Planning Application Ref: BR/229/17/PL (Prev BR/200/16/PL Withdrawn)

Location : Land rear of 41 to 47 Pevensey Road, Bognor Regis

Description of works: Construction of 4 No dwellings with access and parking arrangements.

Consultant Arboriculturist

DRAWING TITLE	
Block & Location Plans and Site Section	
DATE	SCALE
Feb 18	1:200 @ A1
JOB NO.	DRAWING NO.
1615	2.13
	CHECKED BY
	REVISION
	DRAWN BY
	GIM

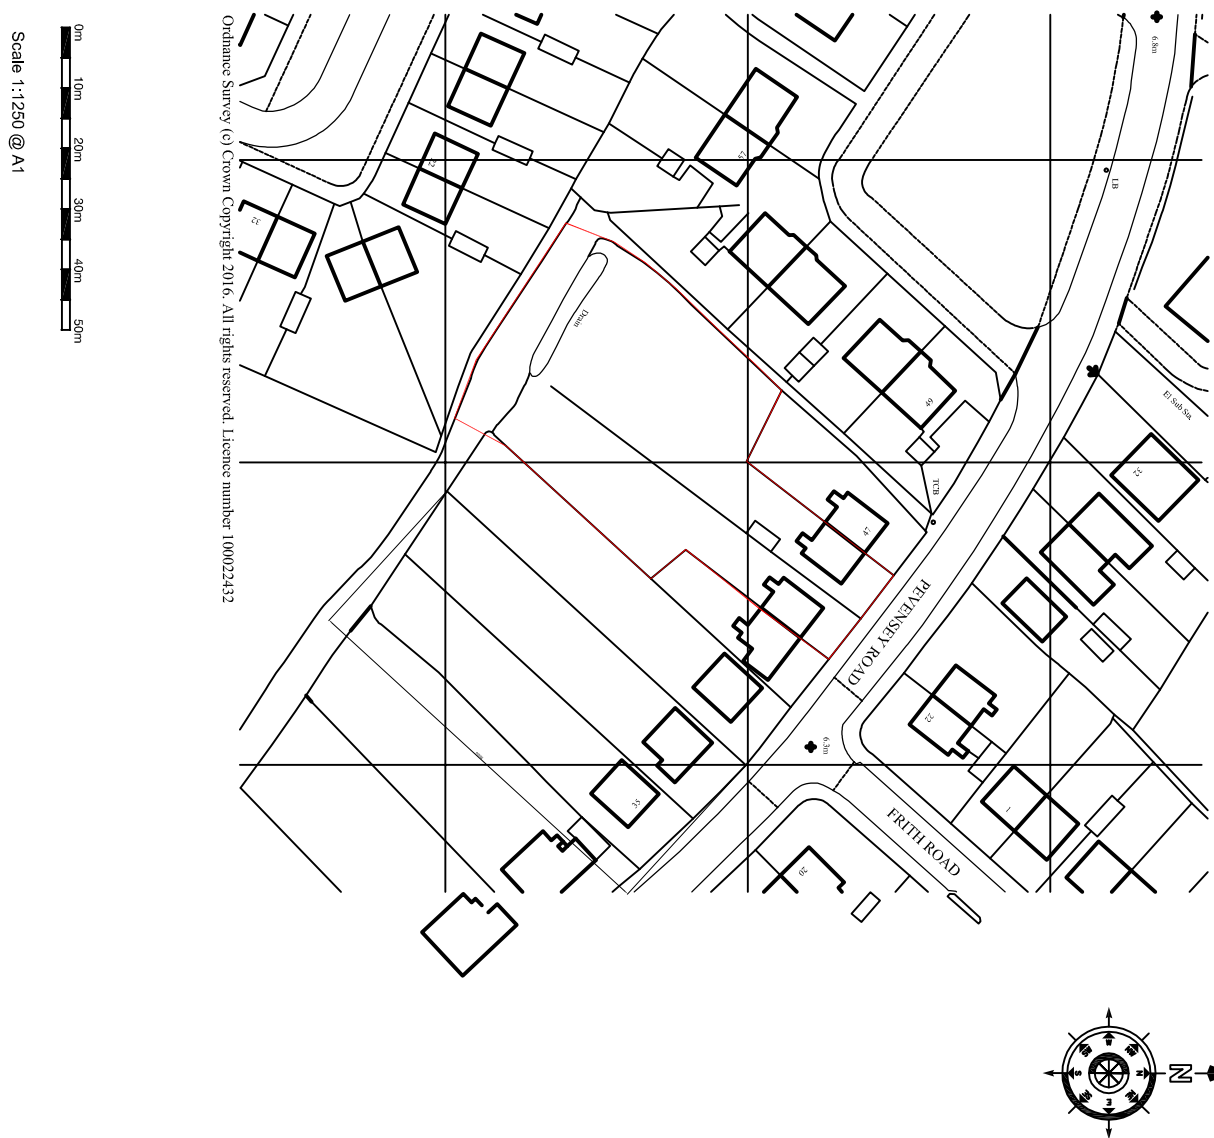
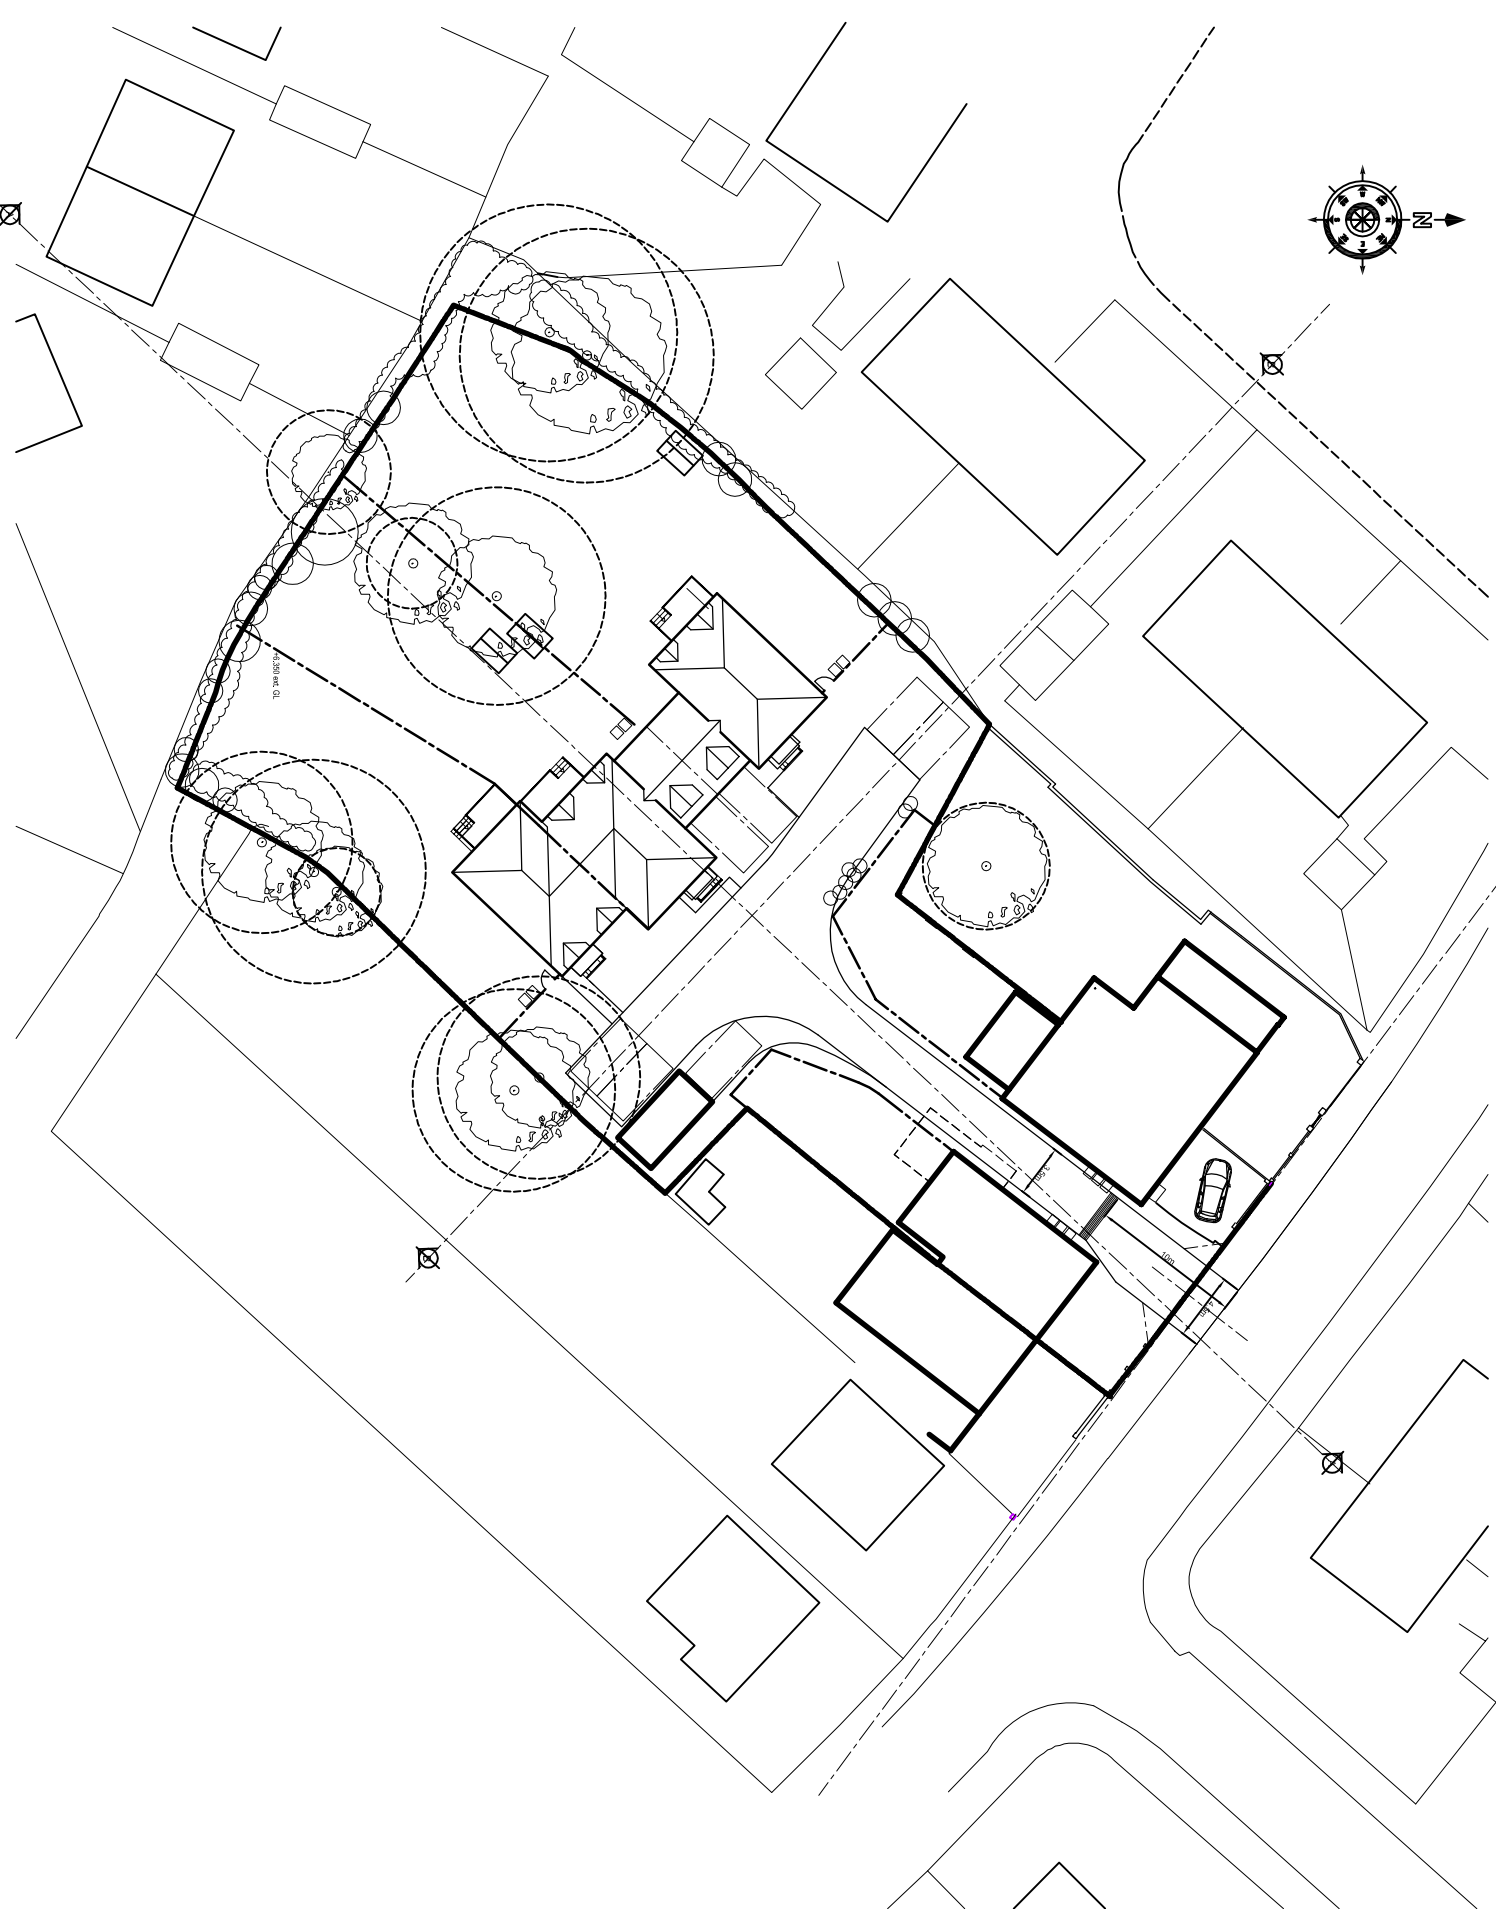
- The primary change to the layout as far as I can see is that Plot 4 has been moved outside of the RPA for trees 11 & 12 and the parking has been relocated along the eastern boundary in front of these two tree and within their RPA.

3. To move Plot 1 a little closer to the tree content in the rear gardens and along the rear boundary line.
 4. To replace the 5 parking bays with two parking bays and one garage block – with the garage block outside of RPA's for off-site TPO'd trees.

- The building on Plot 4 although further away will still be shaded by off-site trees in the garden of No 39 (primarily TPO trees T11/12 & T2) so there will still be pressure to prune or fell that would be difficult to resist on application to prune back from the garden by the new owners of Plot 4. This is now Plot 3 BUT my comments regarding shading and pressure to prune or fell have not altered.

- On re-assessment of Plot 1 I also note that it has a very narrow garden and about 50% of this will be directly shaded by trees 19 & 20 both of which are not yet fully grown so the problem can only intensify year on year and once again these will be under pressure from the new occupants for pruning or felling which will be difficult to resist. Only T20 is TPO'd here so T19 could be removed without reference to the local authority and we would have difficulty in resisting an application to prune T20. This situation would be eased considerably if we were looking at three dwellings and not four here – this would also allow the parking to be re-designed to be totally outside of the RPA's of trees T11 & T12. Plot 1 now benefits from a larger garden area but has in the process crept closer to the trees and looks out directly at them - so my comments regarding shading and pressure to prune or fell have not altered.

- Whilst I accept that there is provision within BS5837 to mitigate the effects of the car parking within the RPA's of T11 & T12 I would much rather see them design this out of the scheme rather than 'make it fit' by mitigation. I am also not convinced that the levels would allow the proposed 'No Dig' situation to be applied here and would wish to see east /west cross section drawings submitted to prove that this can really work. **These comments still apply.**
